East West Rail Phase 2

Stage 2 Road safety audit response report

Offline Highways Passing Places – Package 2 – Oxfordshire (A3 Marsh Gibbon – Compound Access)

Document Number: 133735_RW-EWR-XX-XX-RP-CH-000049

Drawing Title
PASSING PLACE A3_P_5 GENERAL ARRANGEMENT

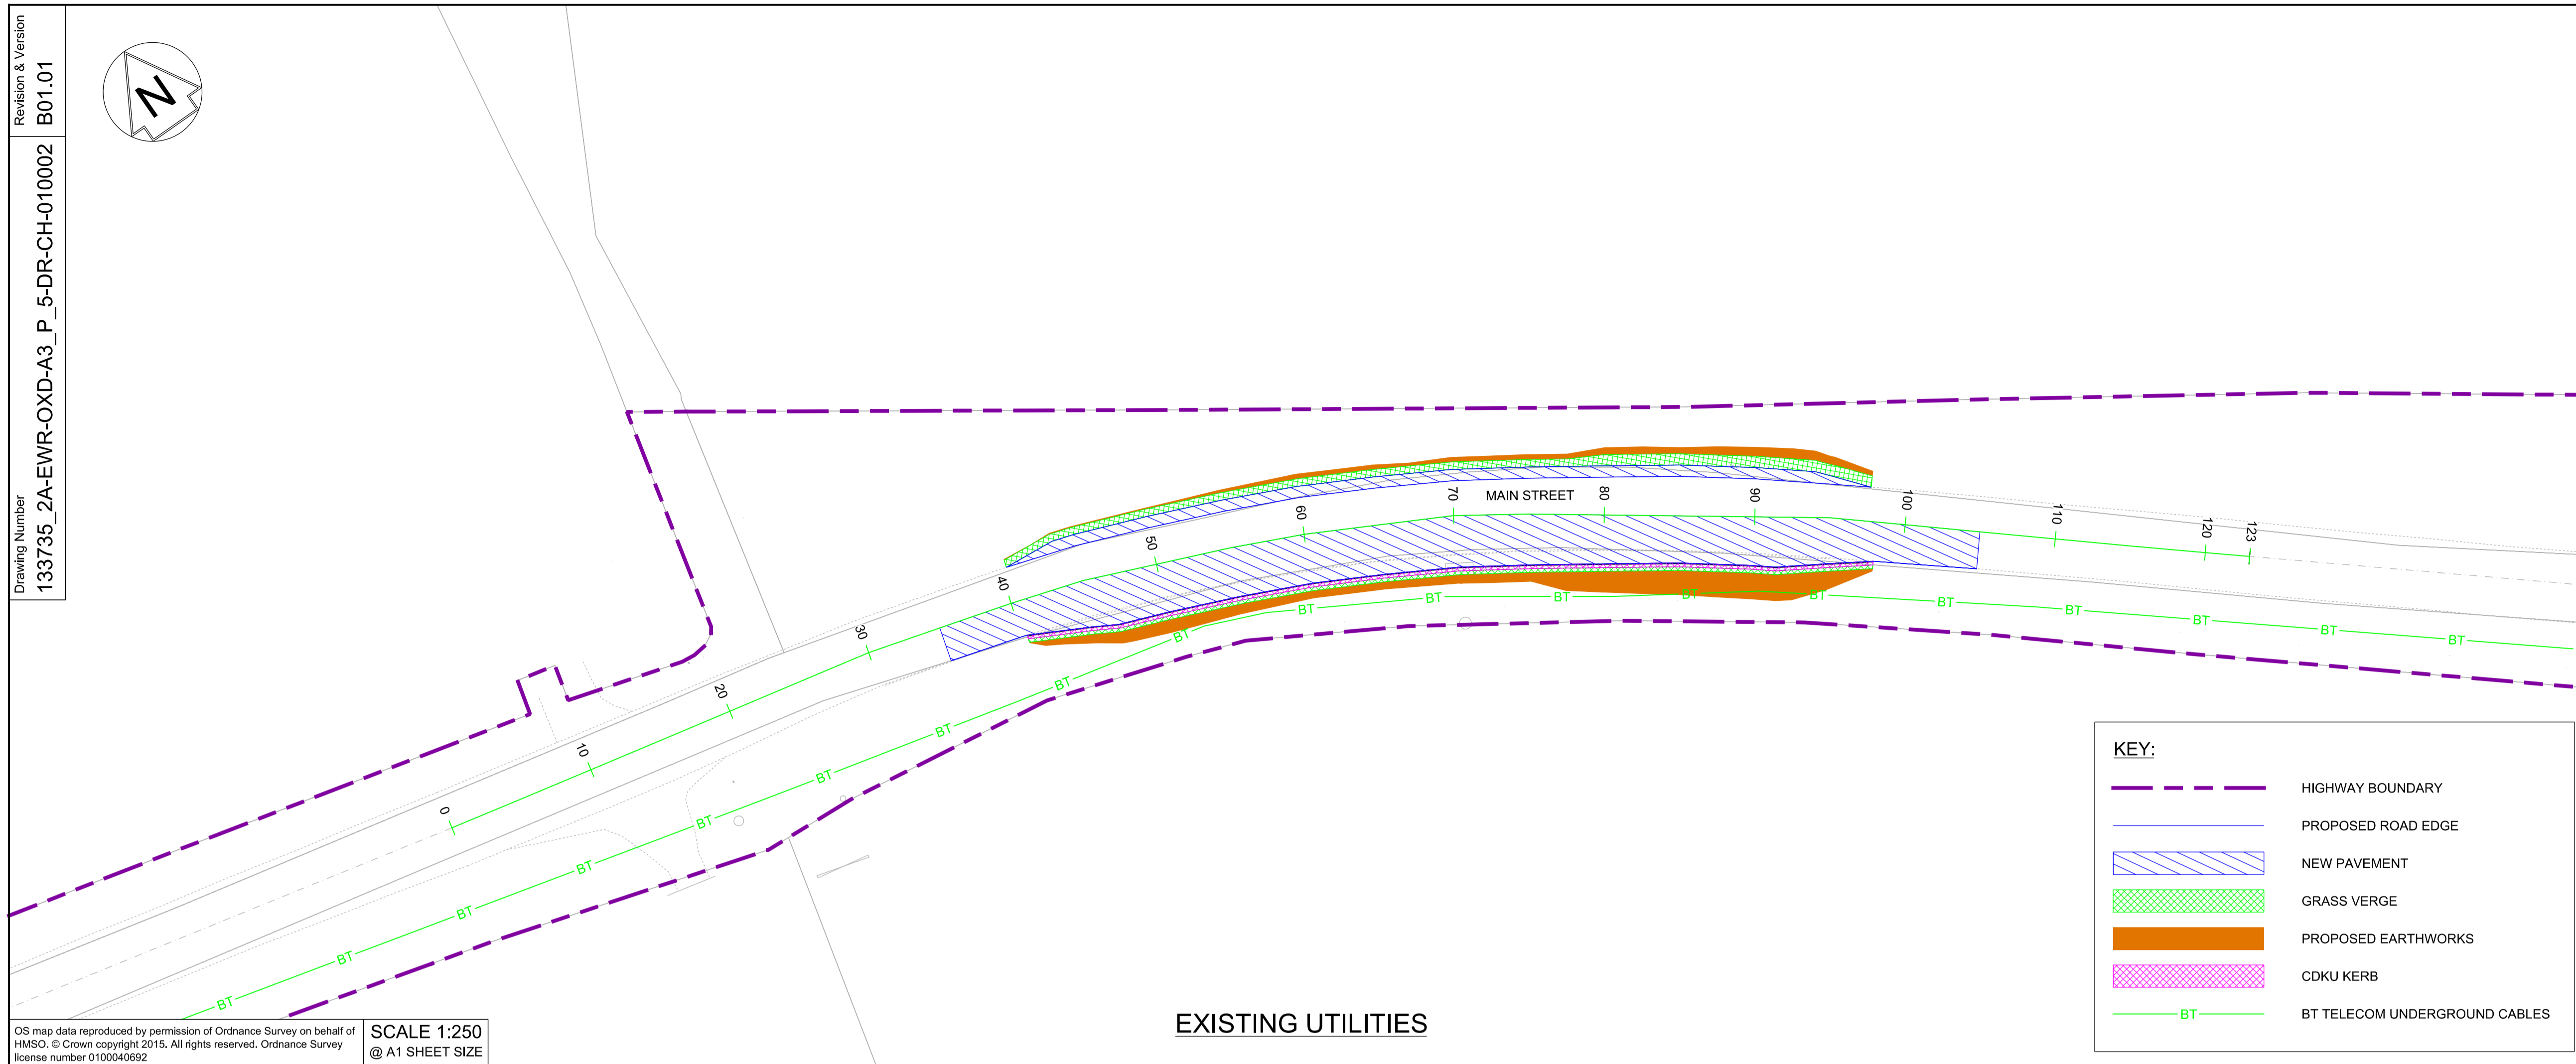
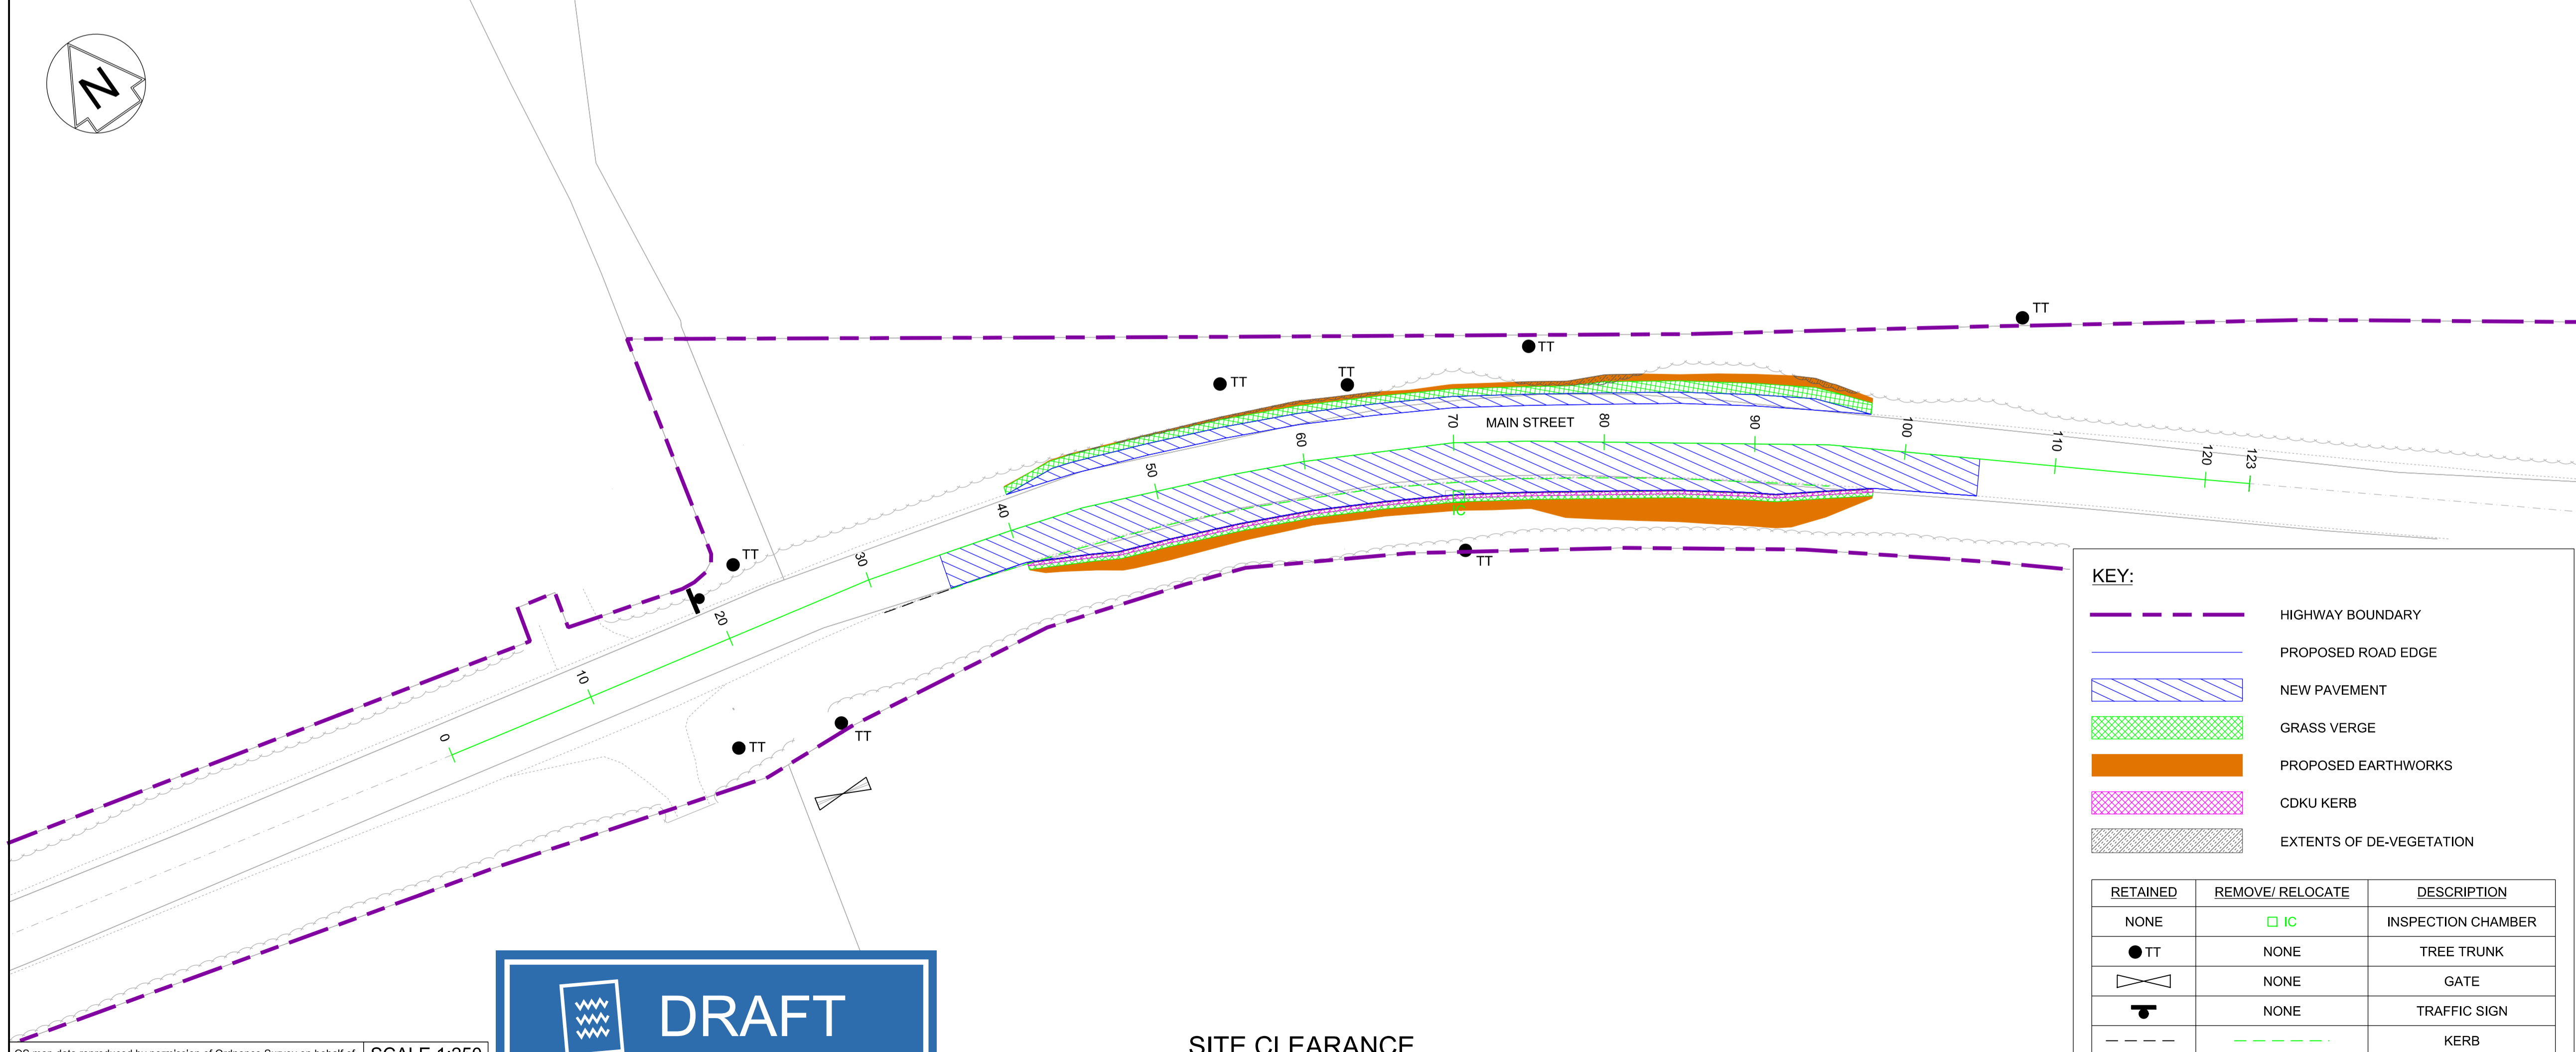
A3-P-5, Unnamed Road (towards Mill Road) – Provide traffic signing to warn pedestrians and construction vehicles of the passing place and presence of pedestrians, respectively. Trim back vegetation around the access to maximise visibility between pedestrians and drivers; or

Remove passing place A3-P-5 (eastbound) as passing place A3-P-6 is adjacent.

2.3	Passing Places A3-P-2, A3-P-5 and A3-P-9. Unnamed Road (towards Mill Road).	Proximity of passing place to public footpath access increases risk of pedestrian being struck by vehicle There are access to public footpaths directly from Unnamed Road (towards Mill Road) in the nearside verges just before the proposed passing places A3-P-2 and A3-P-5. The proposed location of passing place A3-P-9 is directly between the accesses to public footpaths on the north and south sides of Unnamed Road (towards Mill Road), with the passing place clashing with the access on the southern side. Due to the location of the passing places, there is an increased risk of a construction vehicle striking a pedestrian as they enter Unnamed Road (towards Mill Road), particularly as the construction vehicle will be preparing to enter the passing place. This issue is exacerbated by the lack of footway along Unnamed Road (towards Mill Road) as there is no segregation between vehicles and pedestrians.	A3-P-2, Unnamed Road (towards Mill Road) – Move passing place further downstream of public footpath access and provide traffic signing to warn pedestrians and construction vehicles of the passing place and presence of pedestrians, respectively. Trim back vegetation around the access to maximise visibility between pedestrians and drivers	Accept the RSA problem raised but suggest an alternative solution. Passing place to remain in proposed position in accordance with TWAO. Traffic signing to warn vehicles of the presence of pedestrians in advance of the public right of way interface shall be provided, on the northbound approach and before A3-P-2 and on the southbound approach and before A3-P-2. The site clearance drawings shall include vegetation clearance around the public right of way interface to maximise visibility for pedestrians and drivers. The RSA recommendations with respect to warning signage for pedestrians accessing the carriageway from a public right of way will be shared with the logistics team for inclusion.	Accepted	Proceed as Design Team Response

PASSING PLACE A3\_P\_8  
EXISTING UTILITIES AND  
SITE CLEARANCE

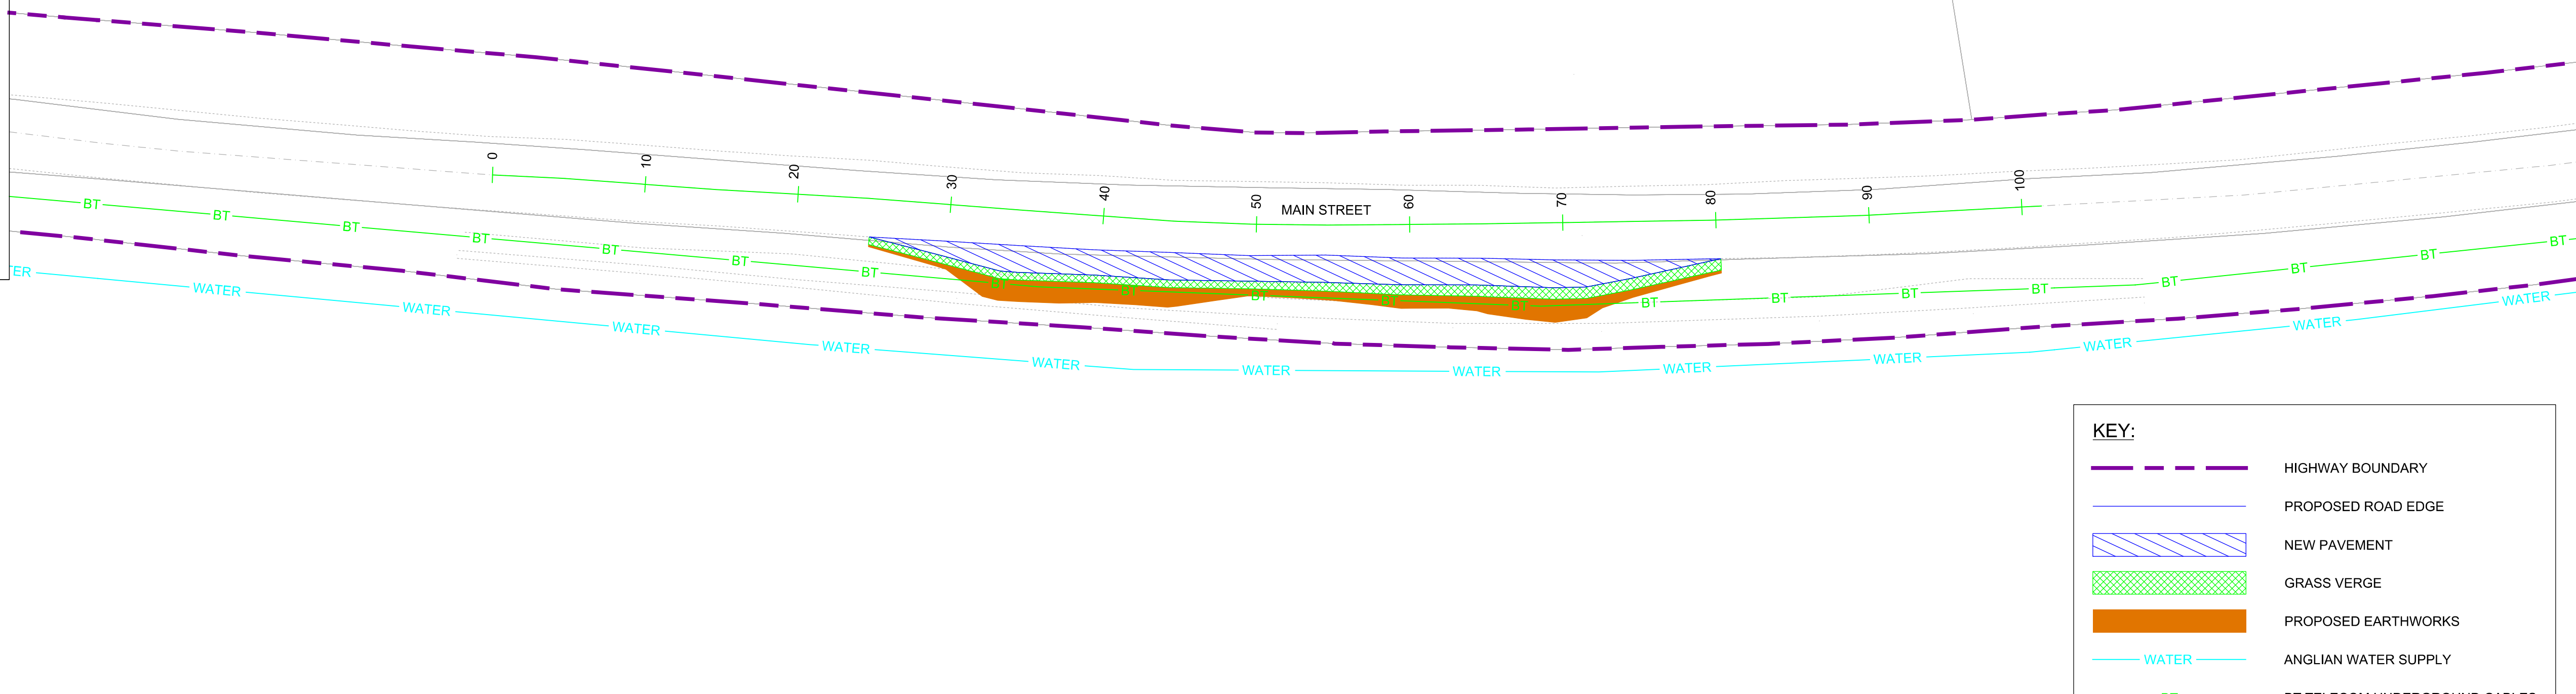
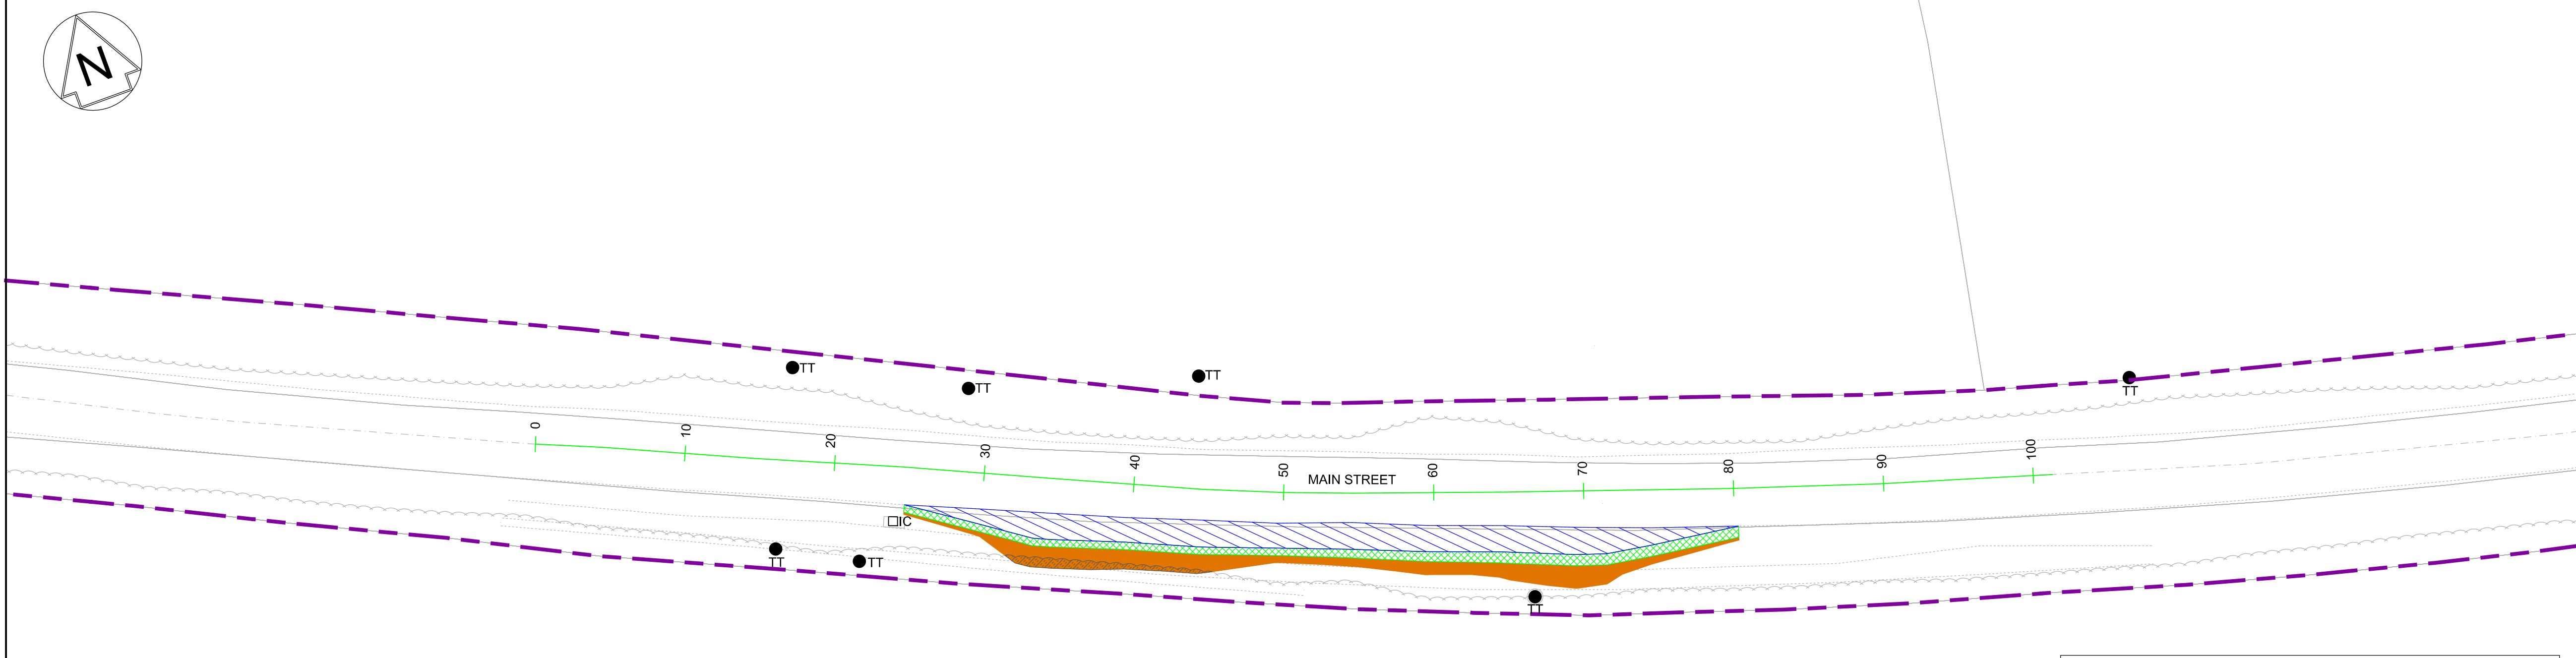
Location: Passing Places A3-P-1, A2-P-1, A3-P-2 and A3-P-8.
Unnamed Road (towards Mill Road).

Summary: Obstructions in verge increase risk of collision

Driver accessibility to passing places is obstructed by trees, and in some locations, signposts situated in the verge. There is a risk that drivers may collide with the trees on entry/exit of the passing place. Also, drivers' forward visibility is restricted by the location of these trees and as such, drivers of construction vehicles may not be aware that they should wait and might proceed, increasing the risk of side swipe collisions. Additionally, approaching drivers may not anticipate the construction vehicle leaving the passing place, leading to side swipe or head on collisions.

Obstructions should be removed from the verges.

RSA Ref	Location	RSA Problem	RSA Recommendation	Design Team Response	Network Rail Response	Agreed RSA action
2.1	Passing Places A3-P-1, A2-P-1, A3-P-2 and A3-P-8. Unnamed Road (towards Mill Road).	Obstructions in verge increase risk of collision Driver accessibility to passing places is obstructed by trees, and in some locations, signposts situated in the verge. There is a risk that drivers may collide with the trees on entry/exit of the passing place. Also, drivers' forward visibility is restricted by the location of these trees and as such, drivers of construction vehicles may not be aware that they should wait and might proceed, increasing the risk of side swipe collisions. Additionally, approaching drivers may not anticipate the construction vehicle leaving the passing place, leading to side swipe or head on collisions.	Obstructions should be removed from the verges.	Accept the RSA problem and recommendation made by the RSA team. The site clearance drawings note that vegetation clearance shall be undertaken to provide suitable visibility. There is also a note for the lifting of tree crowns to provide 5m clearance above ground level to the back of the proposed verge.	Accepted	Proceed as Design Team Response
